**KIRKLEES METROPOLITAN COUNCIL
INVESTMENT & REGENERATION SERVICE**

DELEGATED DECISION TO DETERMINE PLANNING APPLICATIONS

Reference No:	2024/62/91932/E
Site Address:	Land adj, 33, Brooke Street, Cleckheaton, BD19 3RY
Description:	Erection of one dwelling and associated works
Recommending Officer:	Edward Cheseldine

DECISION - REFUSED

PROJECT	33 BROOKE STREET
SHEET	EXISTING ELEVATIONS

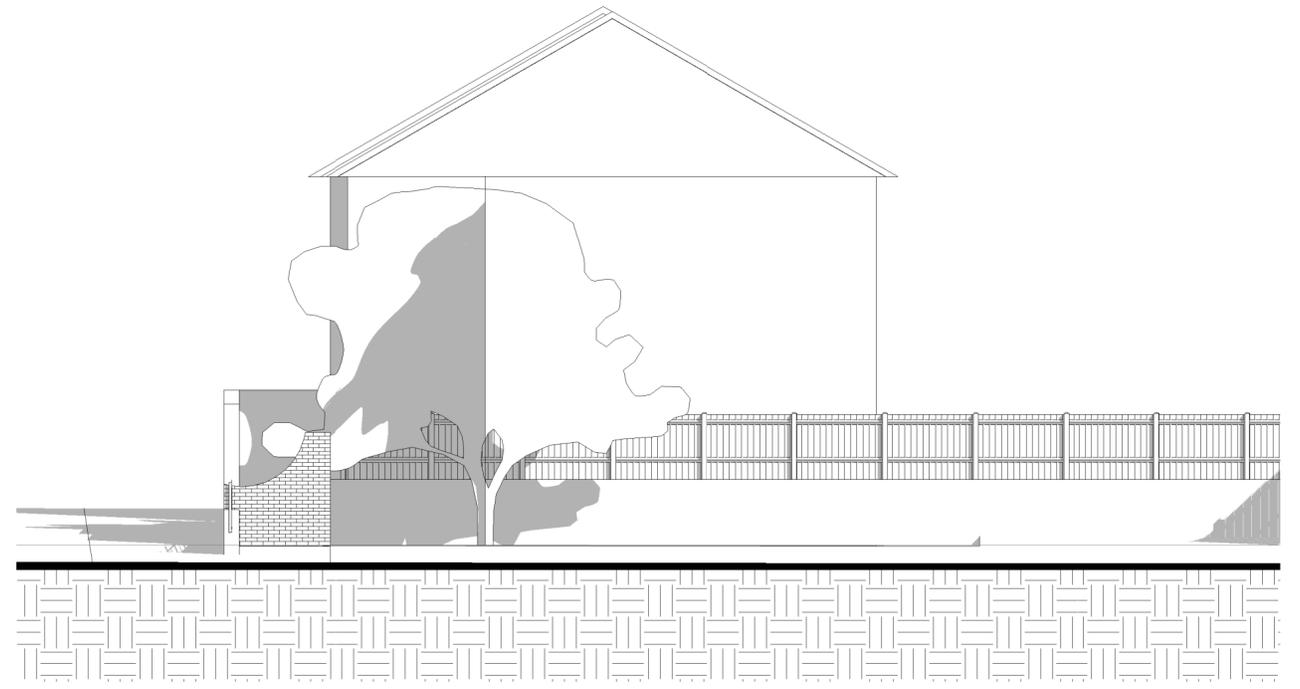
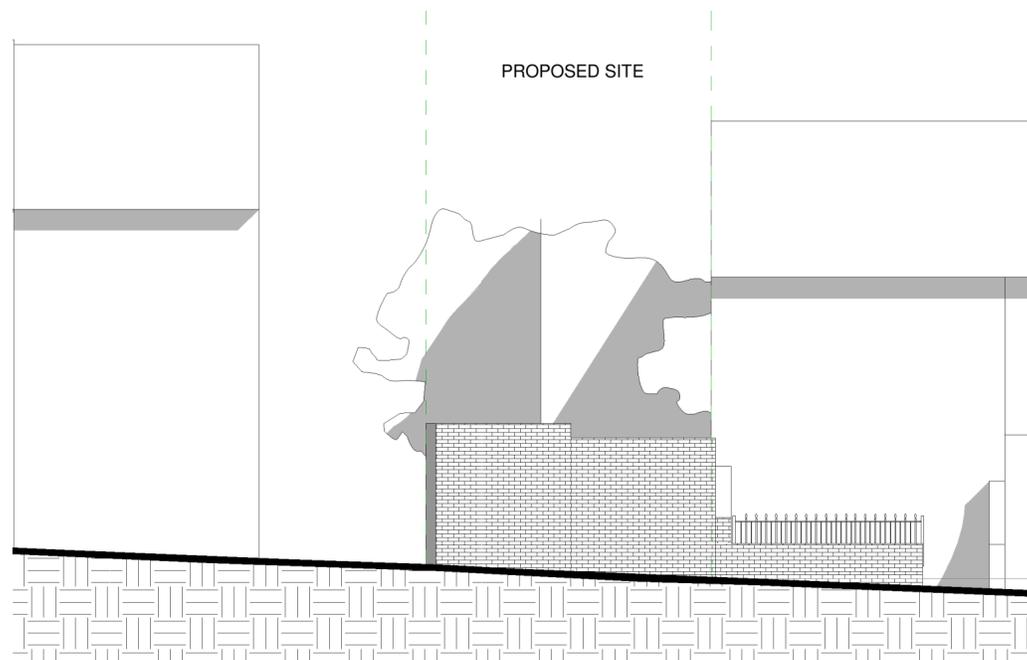
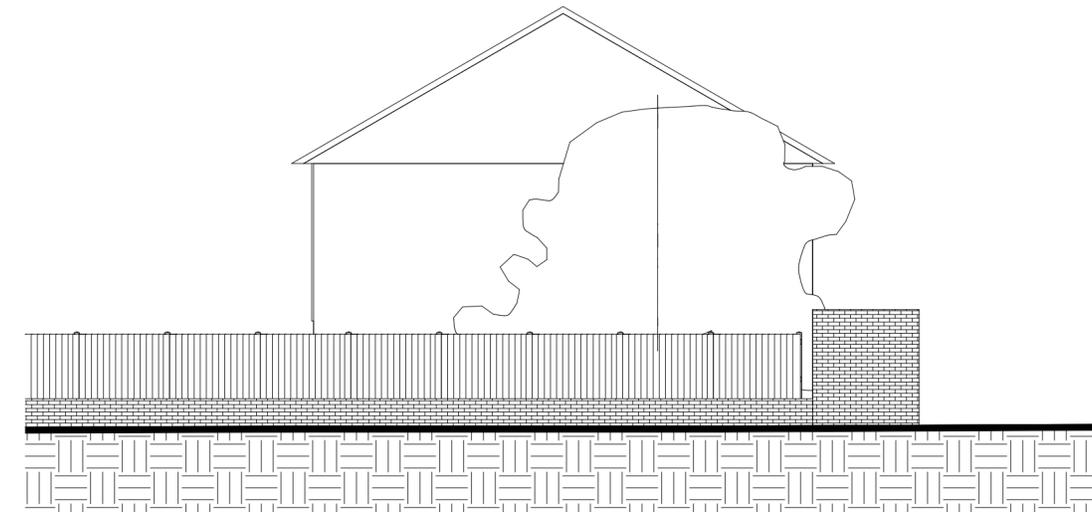
33 Brooke Street will be the adjoining property attached to the building proposed. It currently has two side facing windows. Officers requested floor plans of the building to identify what rooms these windows light. On 16 December 2024, the applicant indicated 33 Brooke Street would require its internal layout re-arranging so that all bedrooms are served with a window. These details were further requested by Officers on 31 October 2025. However, no plans have been received to indicate internal alterations for 33 Brooke Street. In terms of impacts, a new dwelling attached to the side of this property would remove the sole outlook for a bedroom window which would result in a total loss of outlook and light for a habitable room, which would be contrary to Principle 6 of the Kirklees Housebuilders Design Guide SPD, part b & c of Policy LP24 of the Kirklees Local Plan and paragraph 135 of the NPPF.

1. The proposed dwelling, by being attached to the side elevation of 33 Brooke Street, would result in the loss of the sole window serving a habitable bedroom. This would lead to an unacceptable loss of natural light and outlook resulting in substandard living conditions for the occupants. No further plans have been received to indicate otherwise. The development proposed therefore fails to comply with Principle 6 of the Kirklees Housebuilders Design Guide, Policy LP24 b & c of the Kirklees Local Plan and Paragraph 135 of the National Planning Policy Framework.

SHEET
PROPOSED ELEVATIONS

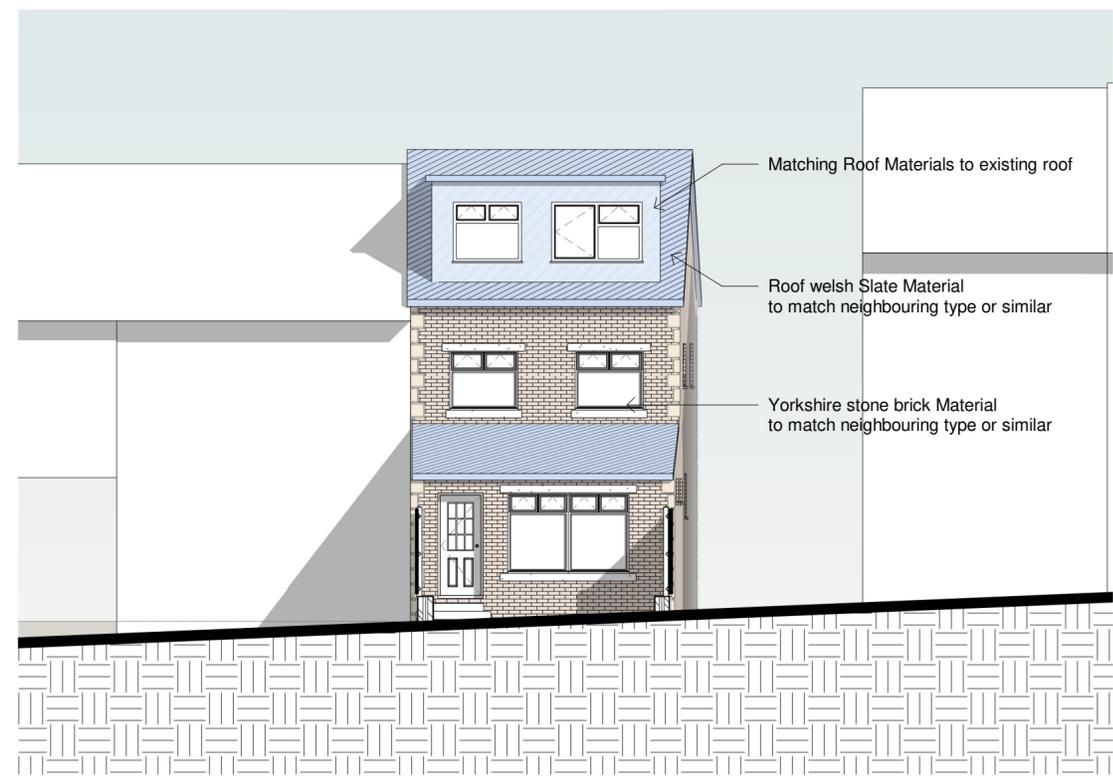
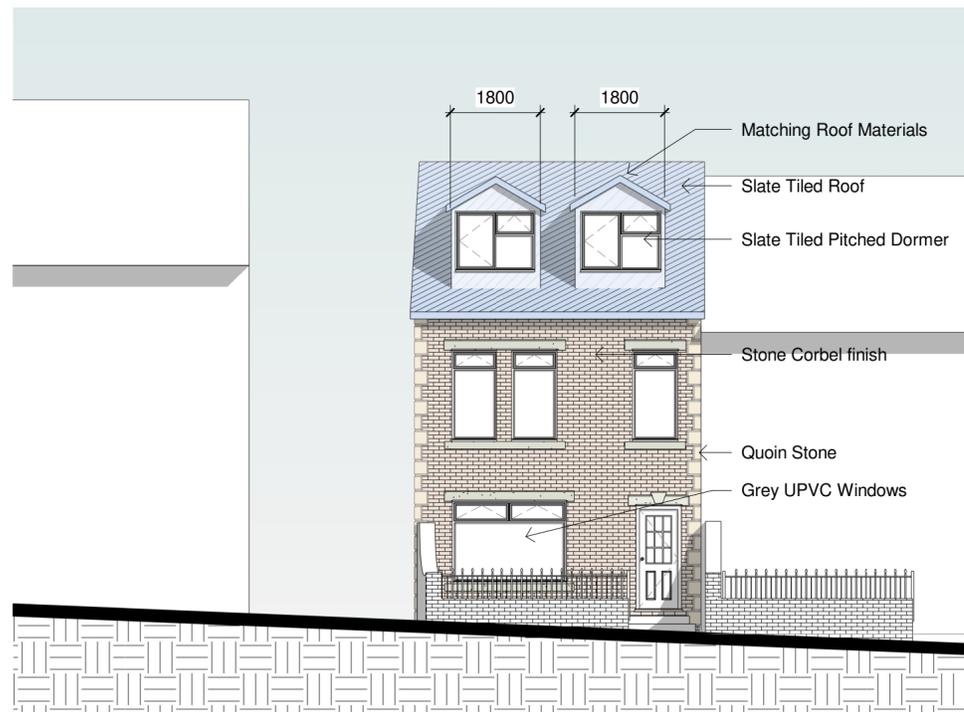
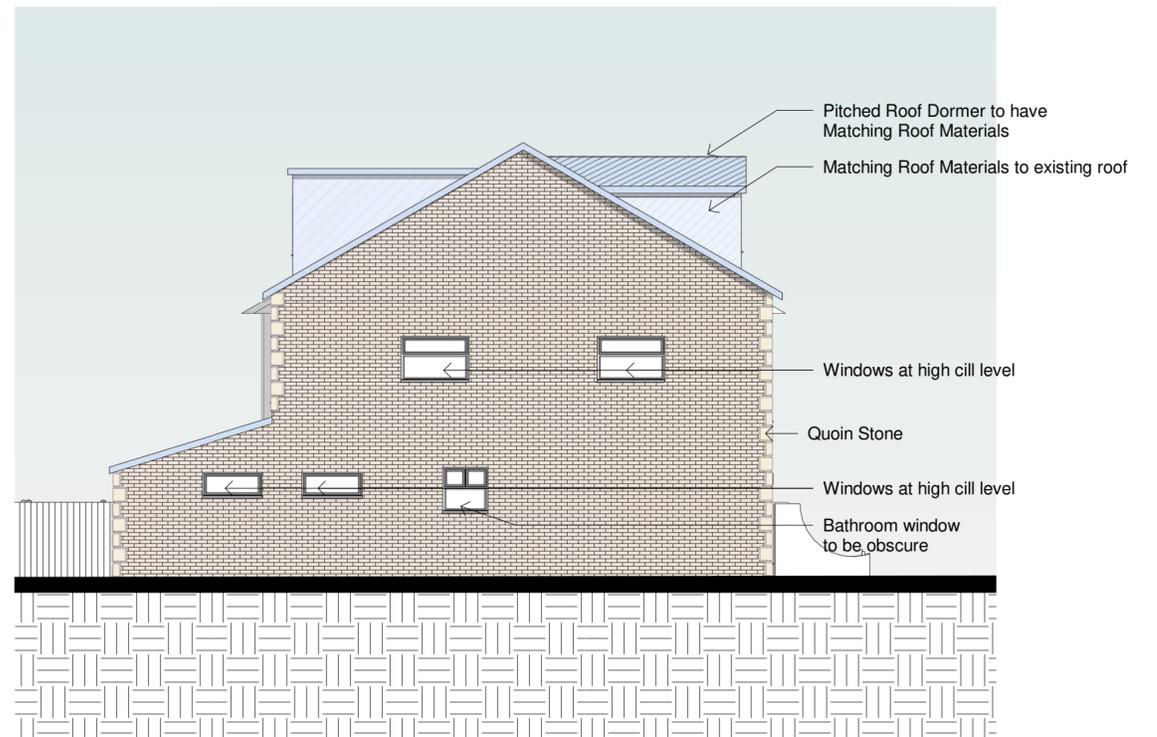
- Details of internal floor changes for 33 Brooke Street due to the side window lighting a bedroom.
- Change of style for the front dormers to a gable-end for a traditional appearance in keeping with the terrace row.
- Introduction of stone features on the front elevation for a traditional appearance in keeping with the terrace row.
- Side windows to be altered.

The new dwelling incorporates features in keeping with the adjacent buildings including stone corbels and sash size openings. The fenestration placement is respectful of the simple nature of the terrace properties. Gable-end dormers will be introduced on the front roof plane which is an appropriate style. Additionally, the building continues the building line of the terrace row.

The ridgeline of the dwelling will sit slightly above the adjoining dwelling. There is a stepped ridgeline between the sets of properties on the north side of Brooke Street due to the slope. The ridgeline will be ~0.50m above the adjoining property. It will not appear dominant due to the slight height increase.

In terms of orientation and placement, the property will face towards Brooke Street. The front elevation will be level with the adjoining terrace. There is a single storey protrusion to the rear that projects 3.00m from the rear of the adjoining terrace. As the extension is single storey, the additional massing is acceptable.

site visit that the three side windows are obscurely glazed. Side windows are proposed to light bedrooms on the first-floor and a bathroom and kitchen/dinner on the ground floor. The side facing windows that light habitable rooms will be high level windows allowing for light, whilst mitigating a direct overlooking relationship if the layout of the adjacent building alters. The bathroom window will be obscurely glazed for privacy. The impact of this window layout is acceptable.

Following the requested amendments, plans were received changing the front dormer style, incorporating stone features on the front elevation and changing the size and height of the side windows.

SHEET
PROPOSED FLOOR PLANS

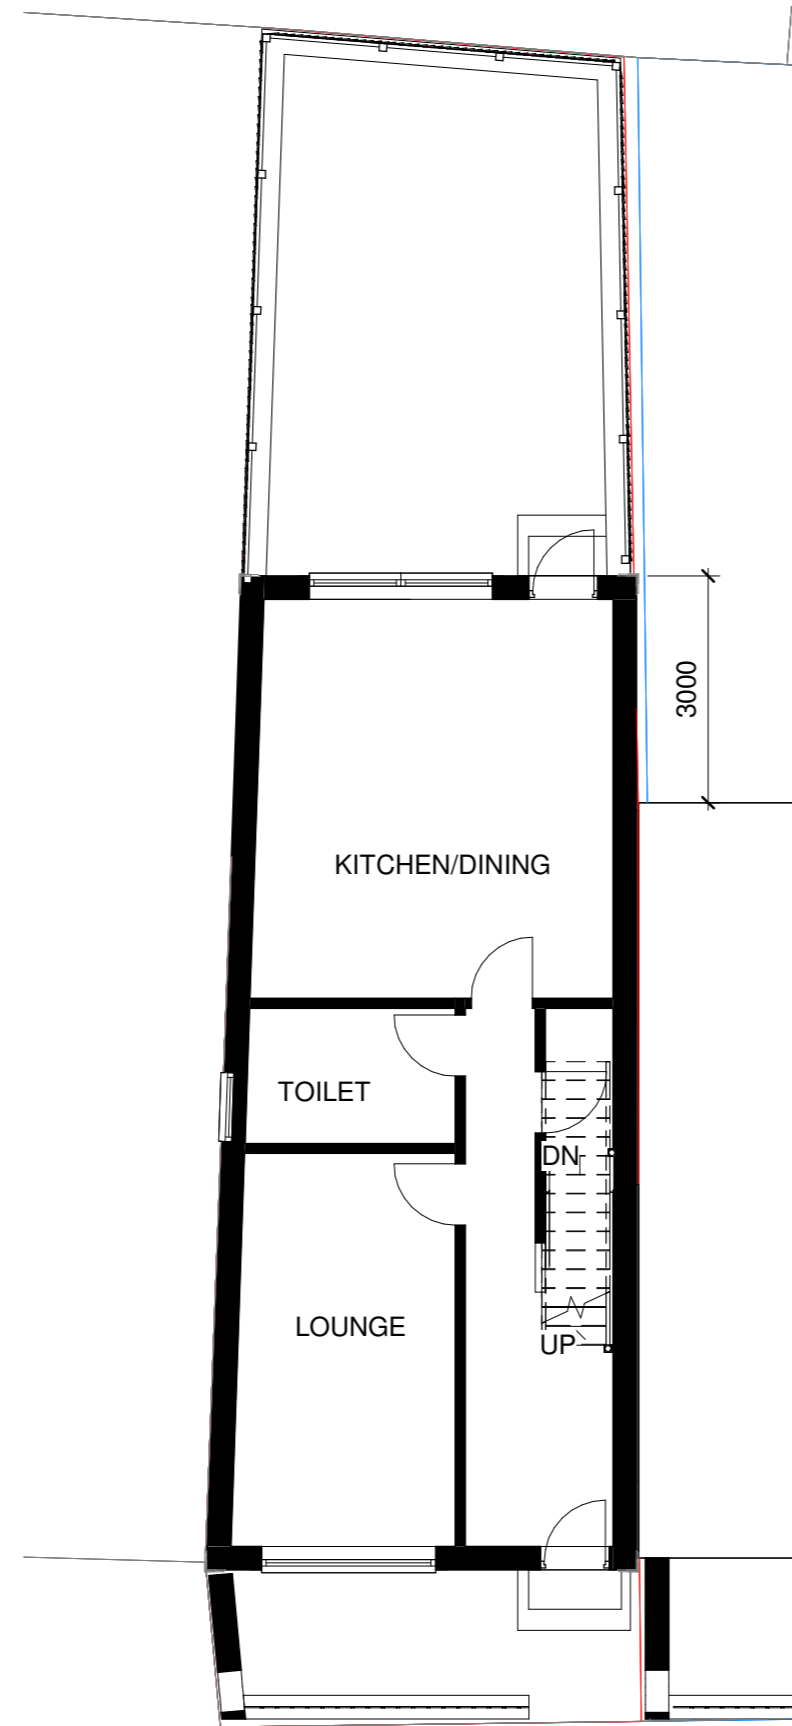
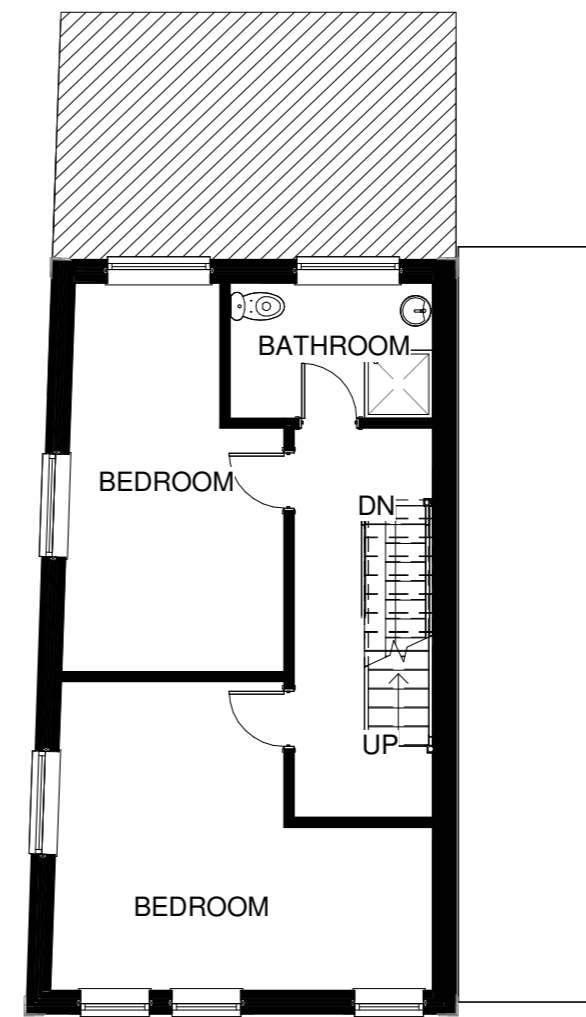
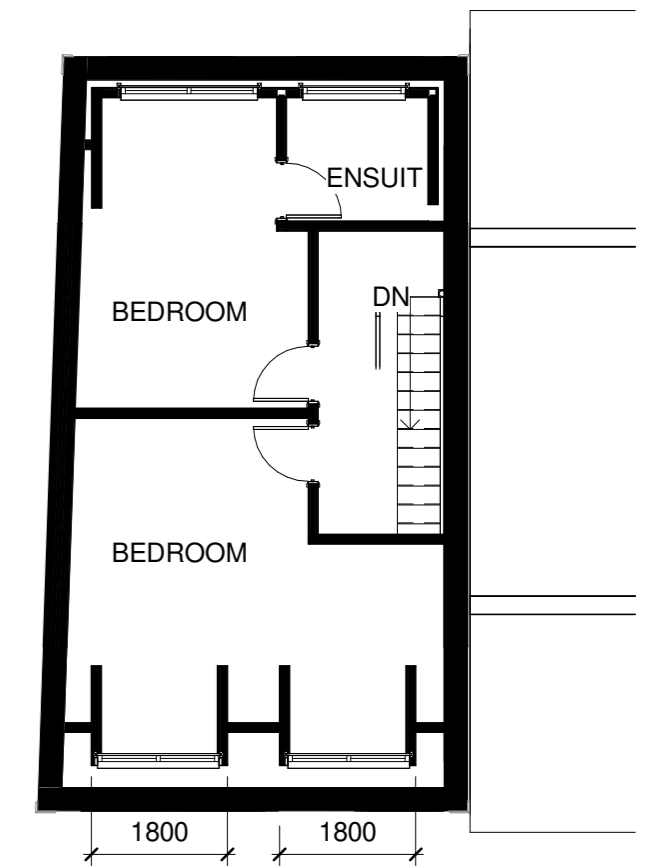
In terms of the rear facing windows of the proposed building, there will be new outlooks from all three floors. In terms of the ground floor windows, boundaries have not been indicated, however it is considered sufficient mitigation could be achieved by way of a condition. The first and second floor window will have an overlooking view into the rear garden of 33 Brooke Street. However, this property is part of a terrace row where the private garden is already overlooked by neighbours. Considering the existing relationship, it is not considered the new outlooks would result in a further impact on privacy that would be to the detriment of the occupant of this building.

The development is for the erection of a four-bedroom dwelling set over three floors. Nationally Described Space Standards (NDSS) outlines such a property must be 103m². The proposed dwelling is set to be 146m² (excluding basement) therefore meeting the guidance. Each bedroom measures 18m², 16m², 12.5m² & 11.2m², therefore meeting the guidance for double and single occupancy rooms set out under NDSS.

Having considered the above factors, it is considered that the proposed development would result in an unacceptable impact on the residential amenity of the adjoining occupiers at 33 Brooke Street. Insufficient information has been provided to demonstrate that the existing internal layout of the property can be satisfactorily reconfigured to mitigate the loss of the affected window. The proposal would result in the complete loss of outlook and natural
